Our Case Number: ACP-323606-25

Re: Proposed construction of 67 no. housing units
on a site at Tyrells Land, situated along Stradbally Road, Portlaoise, Co Laois

Case Reference: JP11.323606

Re: Housing Development of 67 Housing Units etc.
Applicant Further Information Response dated 5 May 2026 to An Coimisiún Pleanála

Figure 4-4 Predicted Flood Depths at Existing Site [1,000- year MRFS]

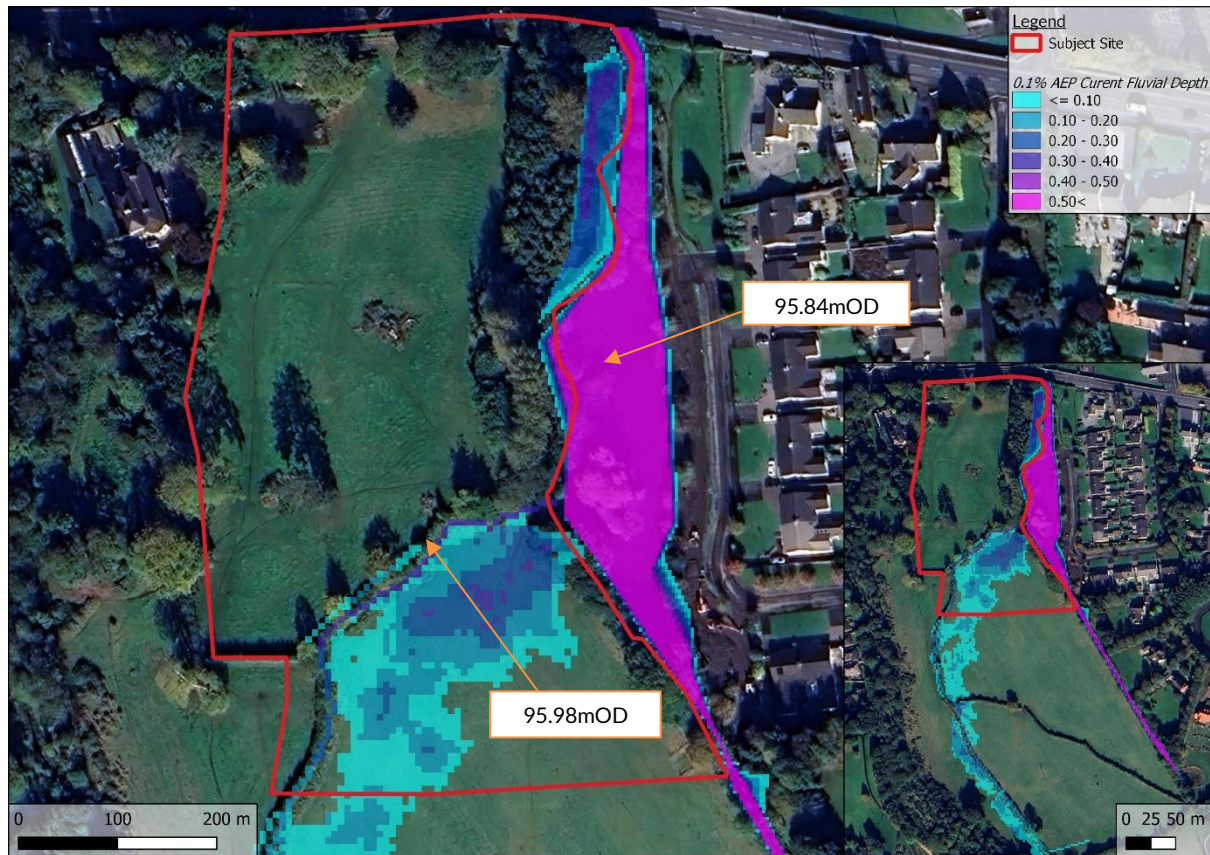
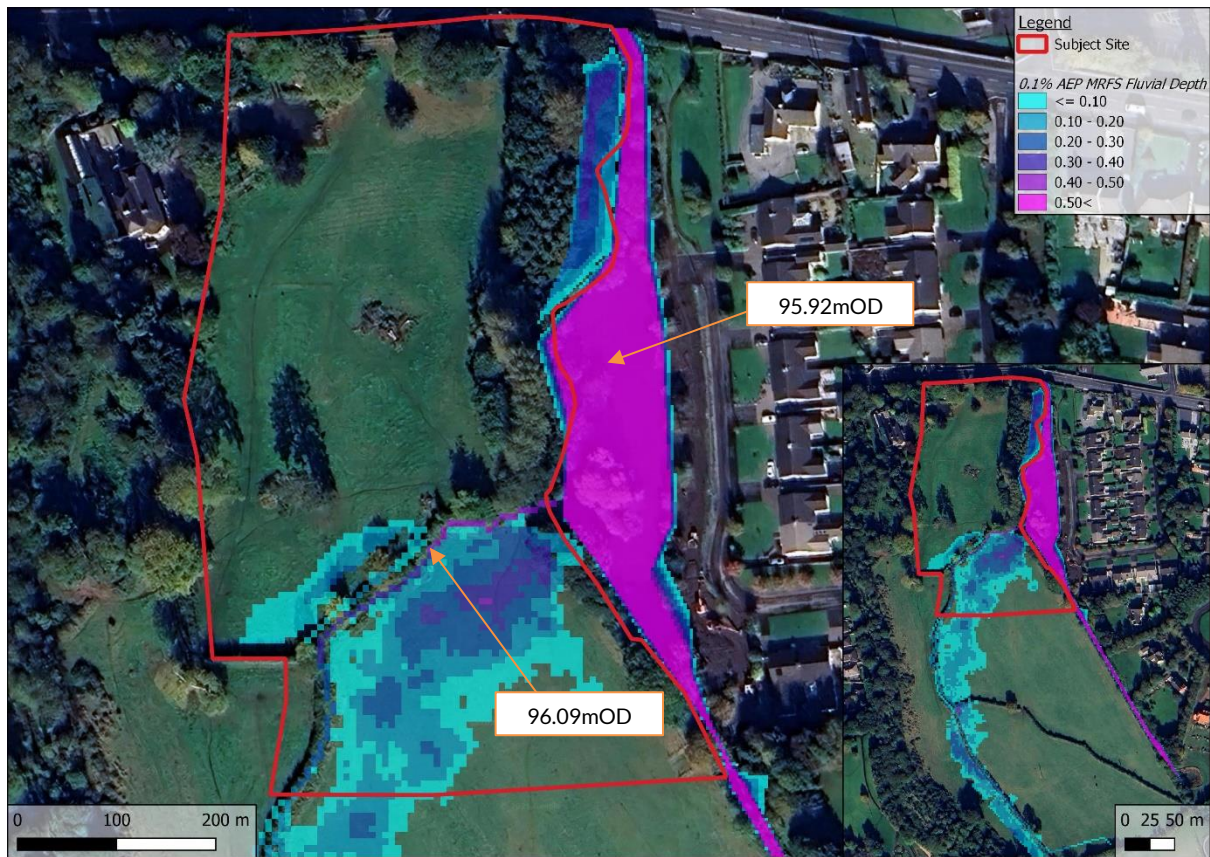
2. Section 5.1 of the Flood Risk Assessment (FRA) submitted by Tobin Consulting Engineers dated 30 July 2025 (Revision C) stated that: "The site-specific hydraulic model showed that the subject site is not predicted to be liable to flooding during the 1 in 1,000-year MRFS flood event." This conclusion was based on an assessment of the site post construction with raised floor levels, rather than an assessment of the greenfield site.
The applicant has further responded that "The CFRAM MRFS mapping shown on Figure 3-5 has since been withdrawn by the OPW for review at this location due to accuracy issues." However, the same map has been reproduced without comment in Revision D of the FRA.
Revision D of the FRA includes a revised Fig 1-2, which includes the proposed flood storage area and a re-alignment of the on-site ephemeral watercourse. Should permission for this development be granted, IFI request that a condition is imposed on the applicant to consult with Inland Fisheries Ireland before any works take place on the proposed stream diversion and adjacent compensatory flood storage on site.
